I am writing as a parent of a child that attends Darlington Public School regarding the proposed development by the University of Sydney, MP 07_0158 – Abercrombie Street Precinct, Syd Uni. Darlington Public School is an inner city school servicing the suburbs of Chippendale, Darlington and parts of Redfern. The school is directly adjacent to the western border of the project.

Drawing title
BASEMENT FLOOR PLAN

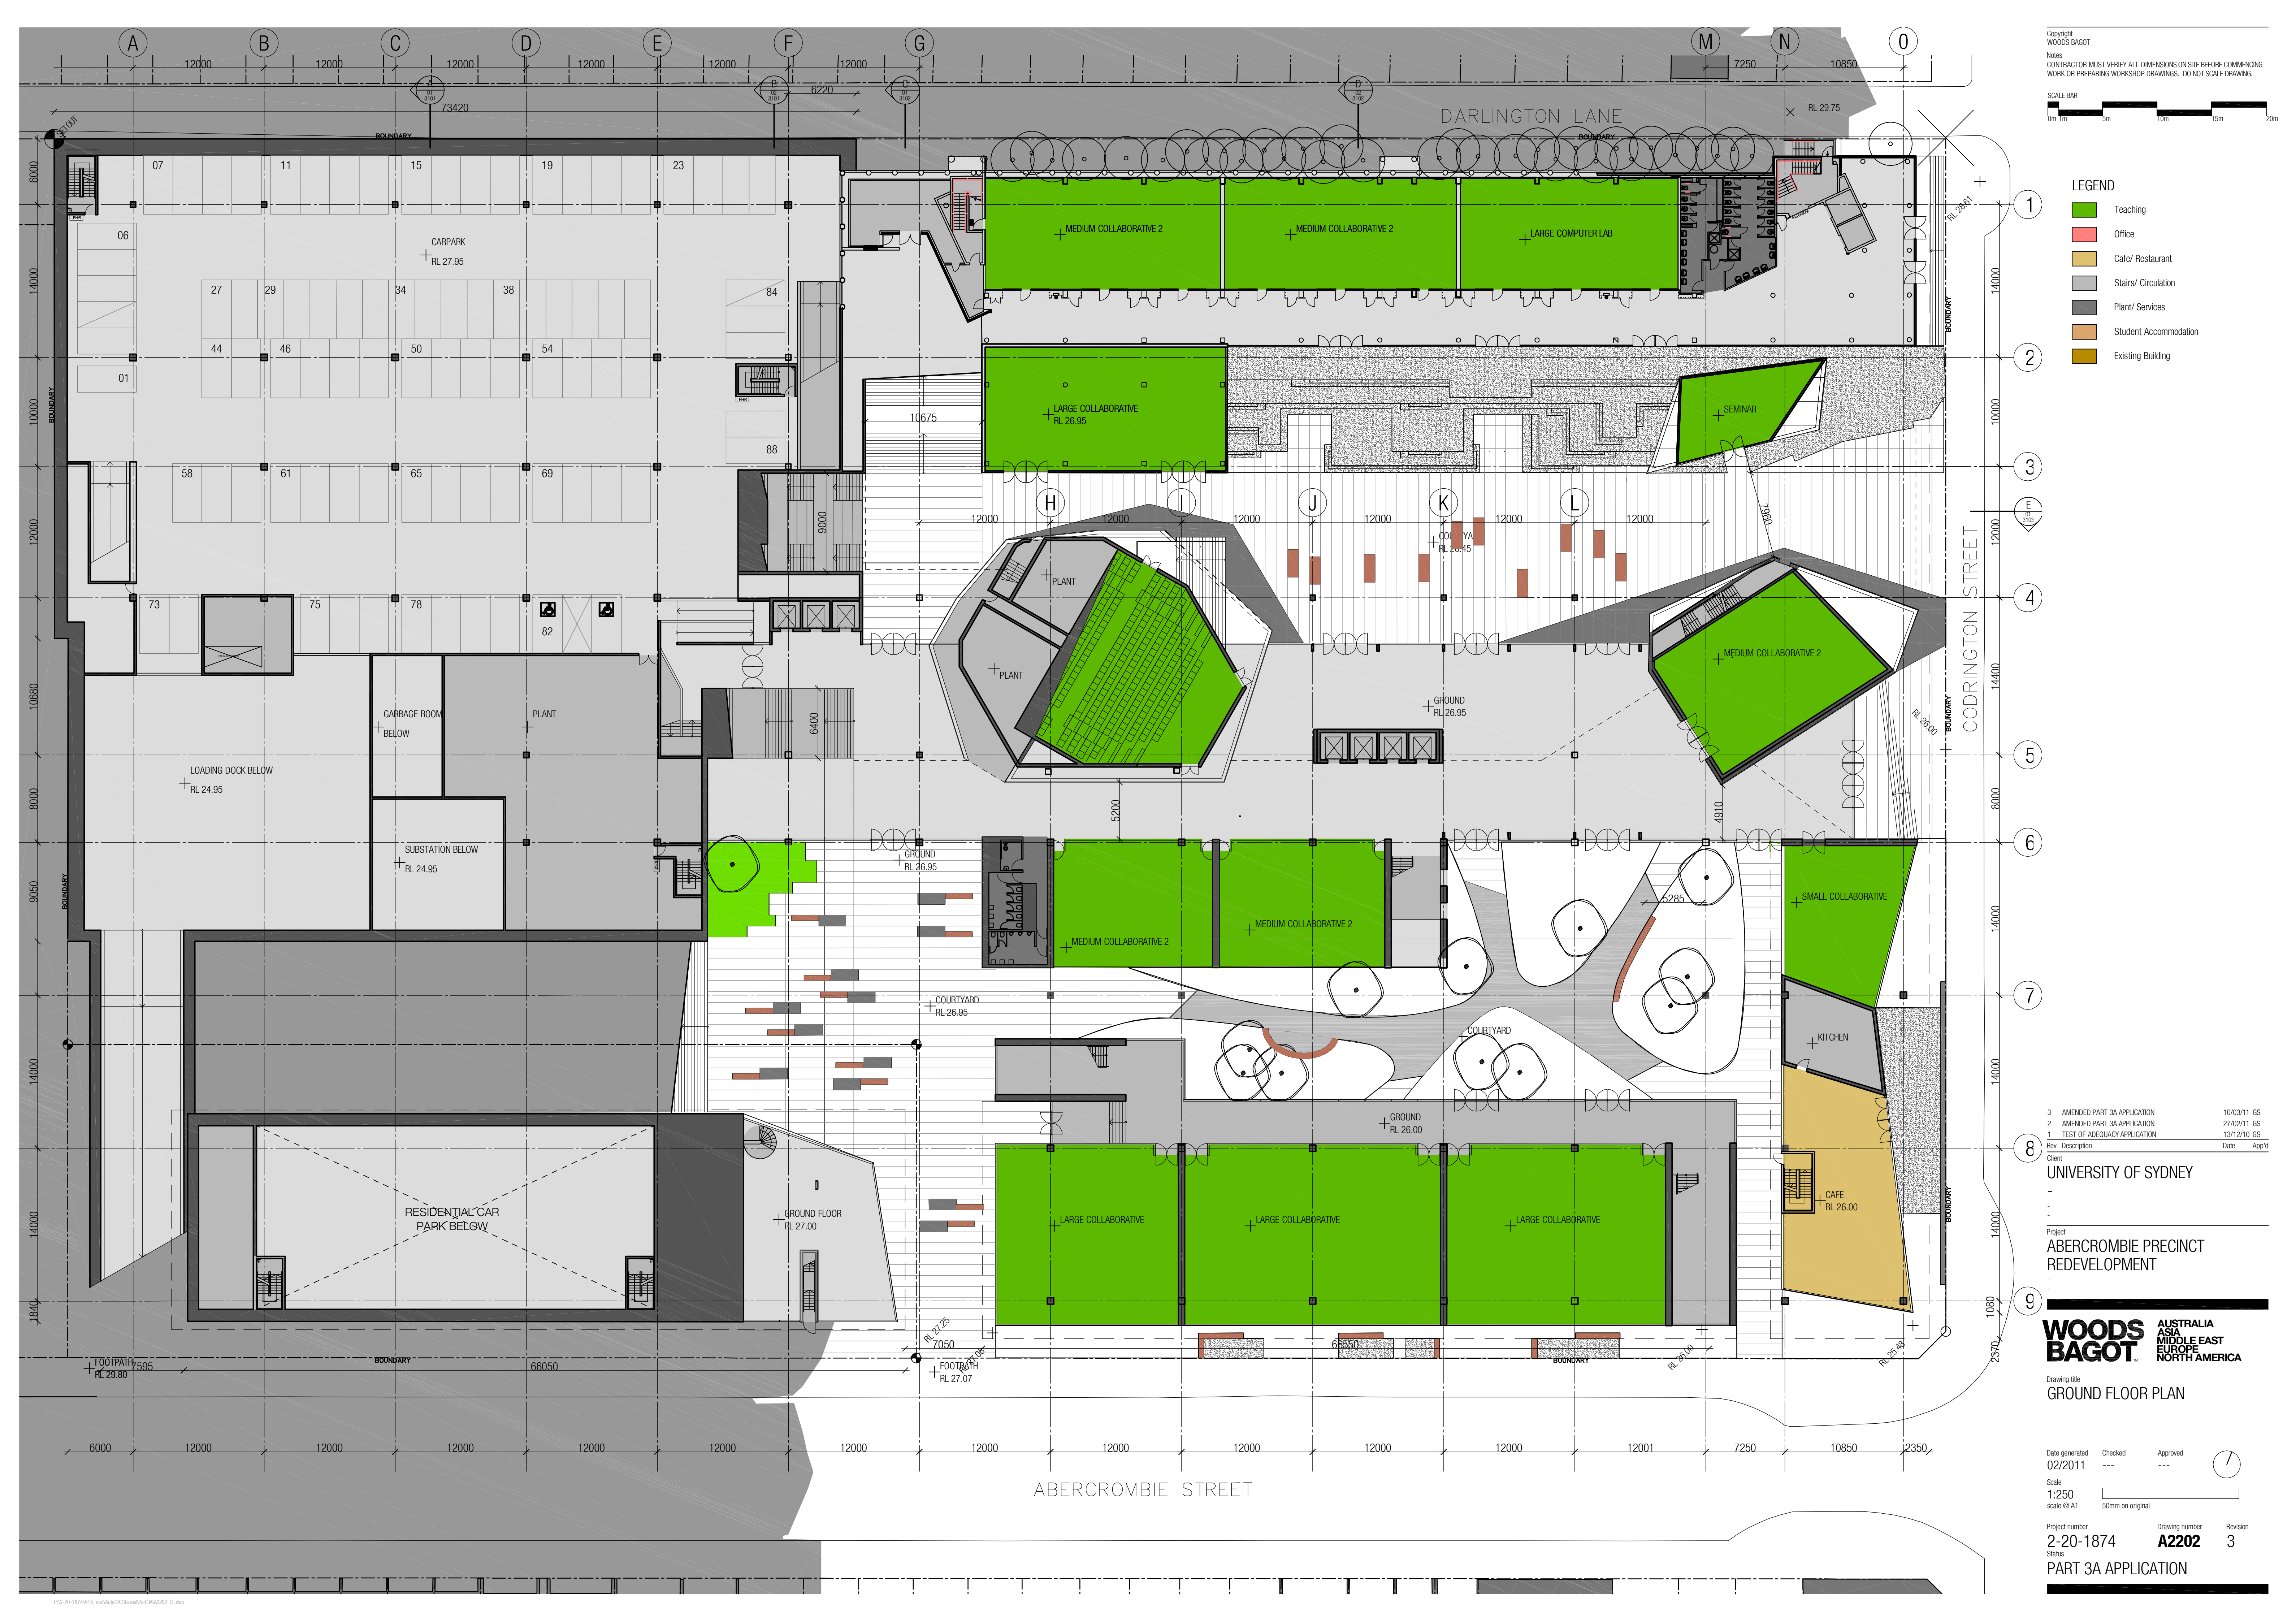
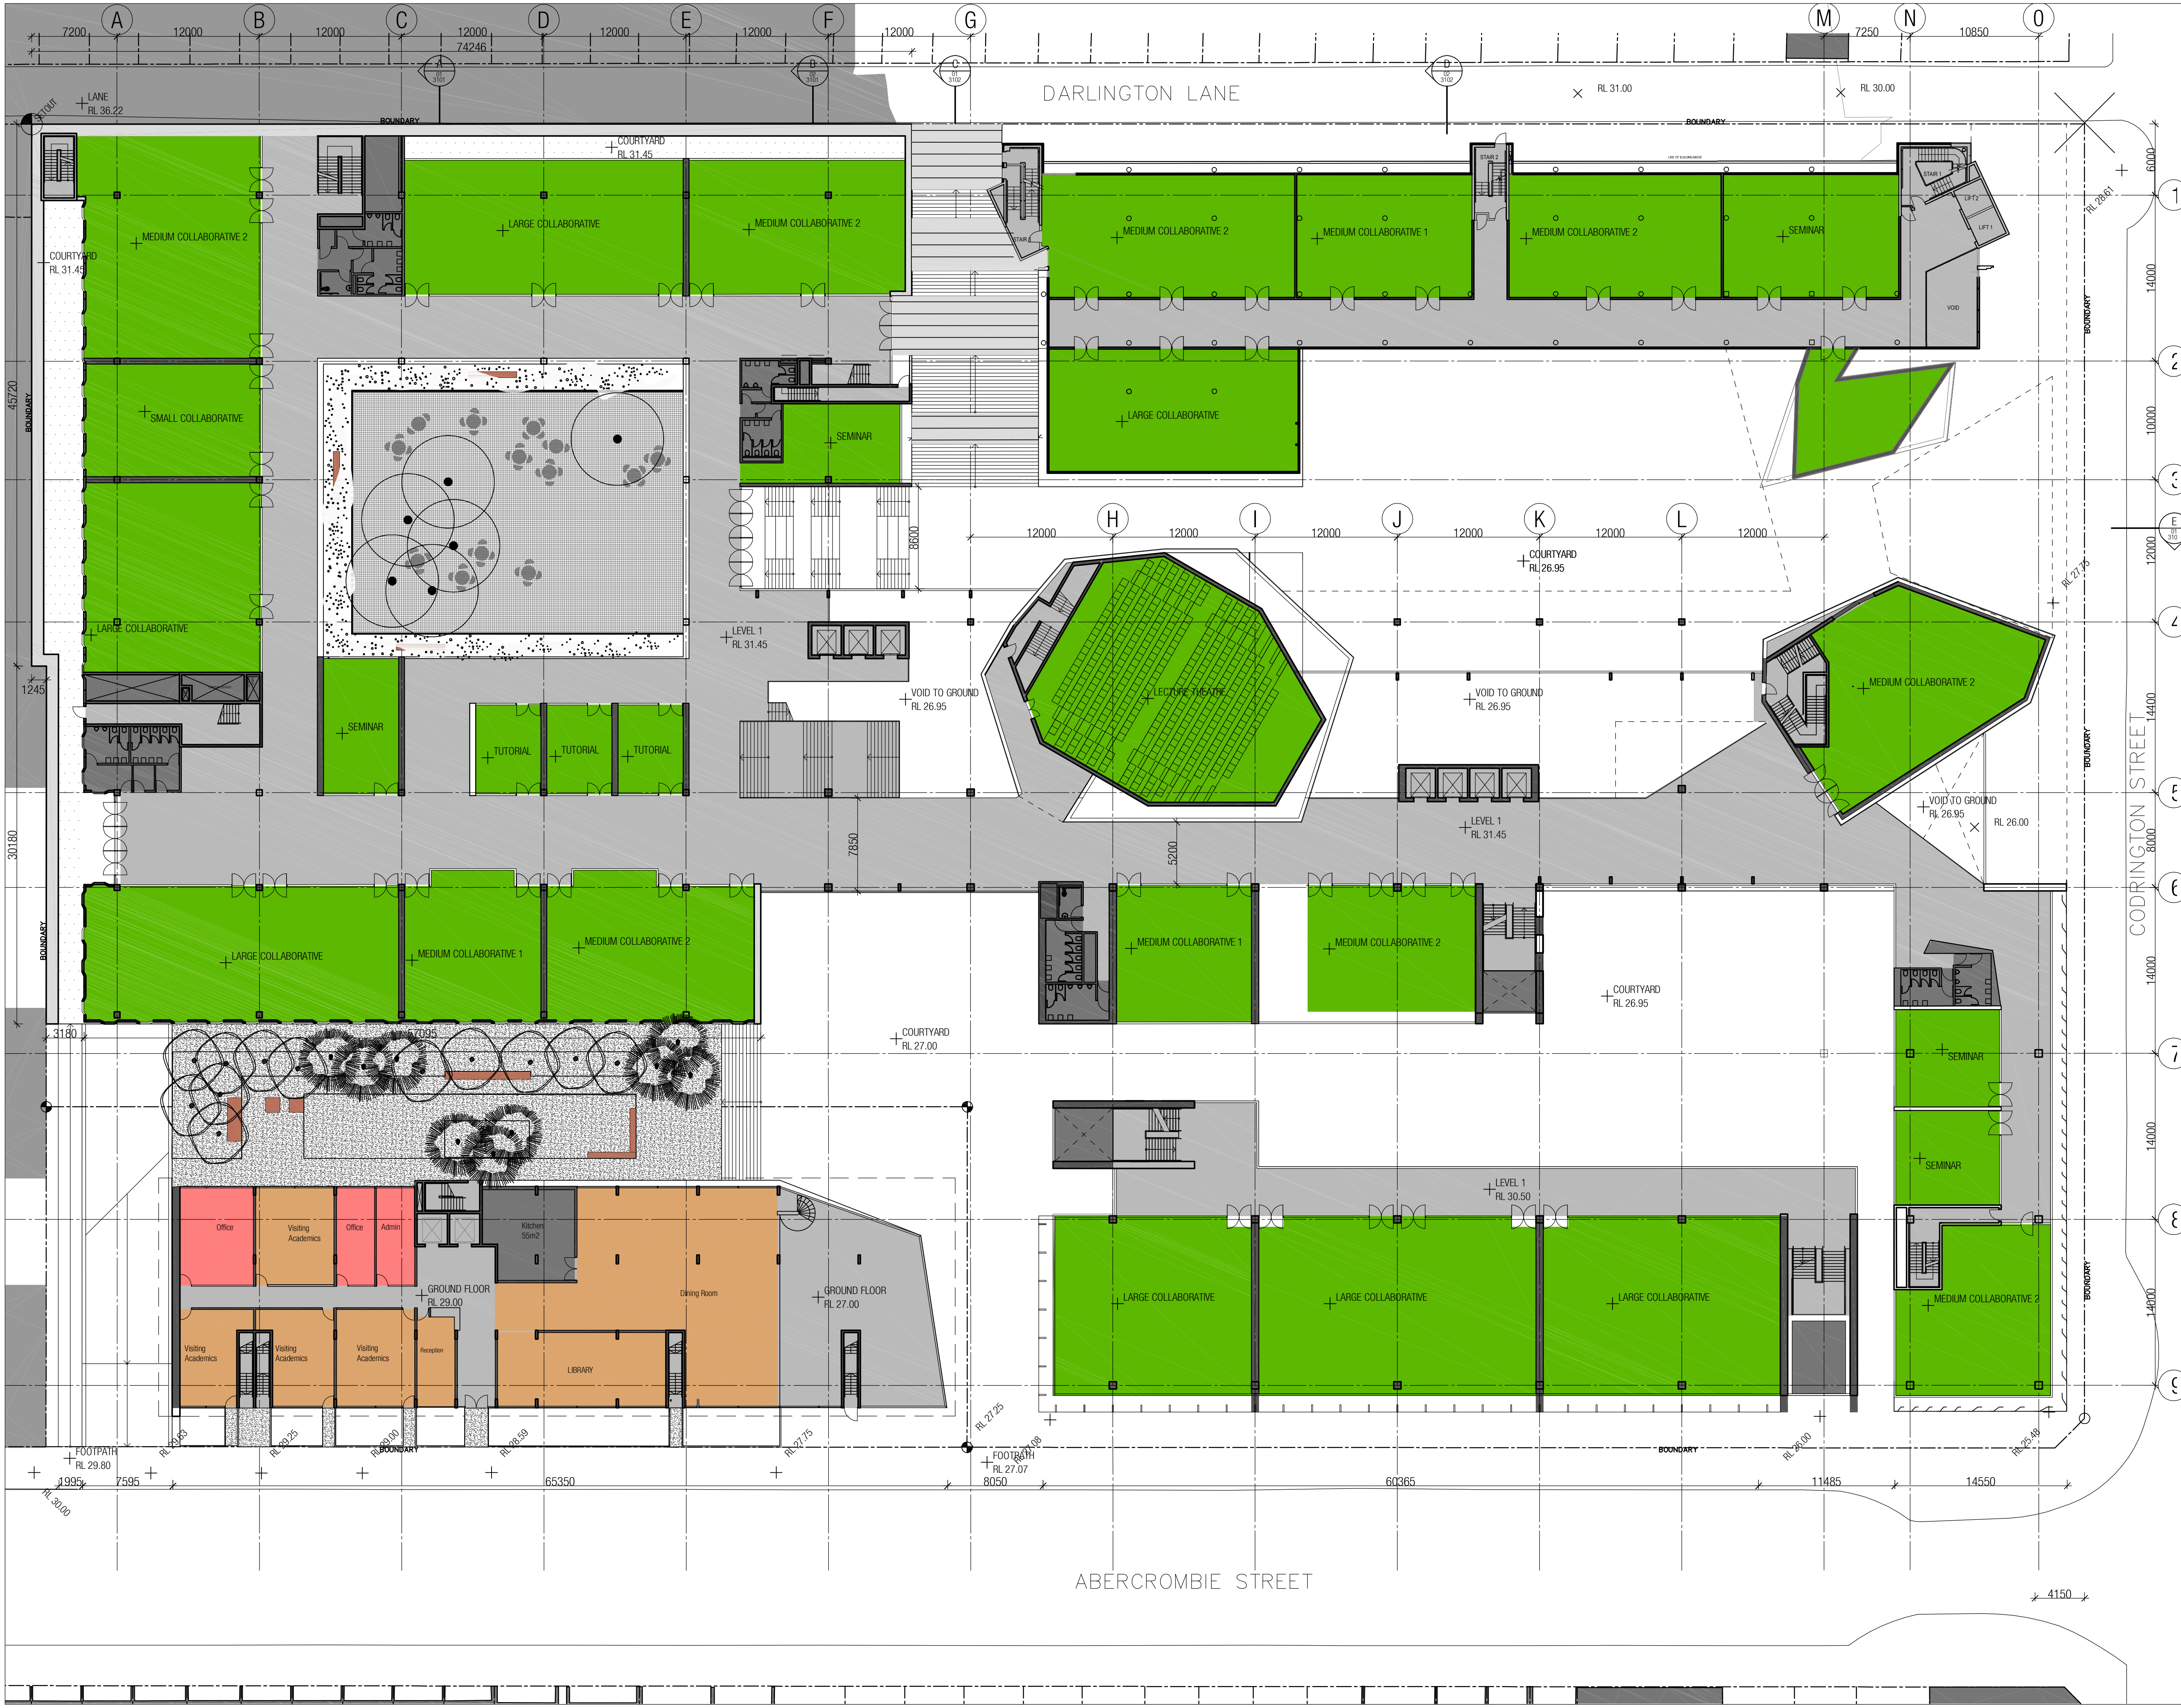
As per the current development plan, the proposal calls for an underground car park to be built for the student accommodation and University staff. The car park will accommodate 185 car spots, and its entrance will be on Abercrombie Street, at approximately the same point of the construction access.

The concerns raised above about the access point to the construction site are the same for this car park access point increasing the risk to school children's safety, in an area that has already been highlighted through the respective organisations (Council, Police, and RTA). The increased traffic flows and access point are an unacceptable risk to the children who attend the school. There is no justification for this level of risk to a school community, particularly as the University has another street frontage without school or residential issues (the University being the only stakeholder for Codrington Street) and an access street internal to project (Darlington Lane).
